Our Ref: 23/04317/FUL
Your Ref: Dale Cambridge COU

South Cambridgeshire District Council Application for Planning Permission

Proposal: Change of use of land from scrubland to residential for the siting a residential annexe (Caravan)

Site address: 8 The Dunnocks Cottenham Cambridgeshire CB24 8XU

Location Plan shows area bounded by: 544905.32, 267851.33 545046.74, 267992.76 (at a scale of 1:1250), OSGridRef: TL44976792. The representation of a road, track or path is no evidence of a right of way. The representation of features as lines is no evidence of a property boundary.

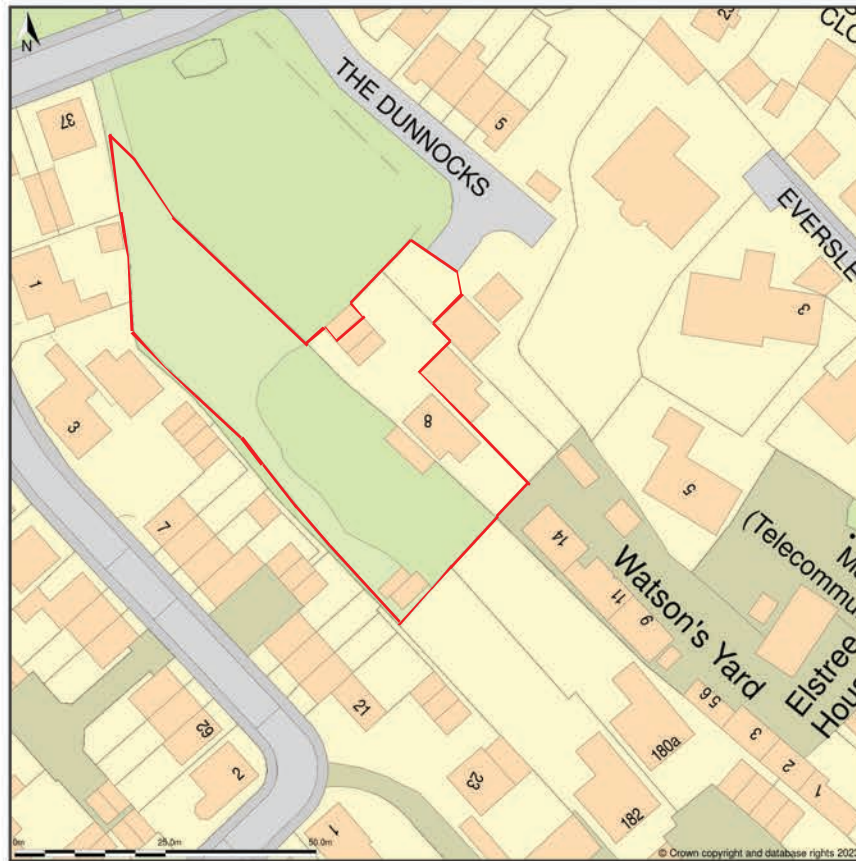
1. It is noted that 2 location plans have been submitted with different extents, please indicate which location plan shows the correct red outline.
2. An additional fee of £231 (Total fee £462) is required for this application. I have transferred the fee of £231 previously paid on the withdrawn application for a lawful development certificate. Please call 01954 713 000 to make a card payment by telephone. When calling select option 5 for Planning and then hold for an adviser. Please quote the full planning reference number shown at the top of this letter.
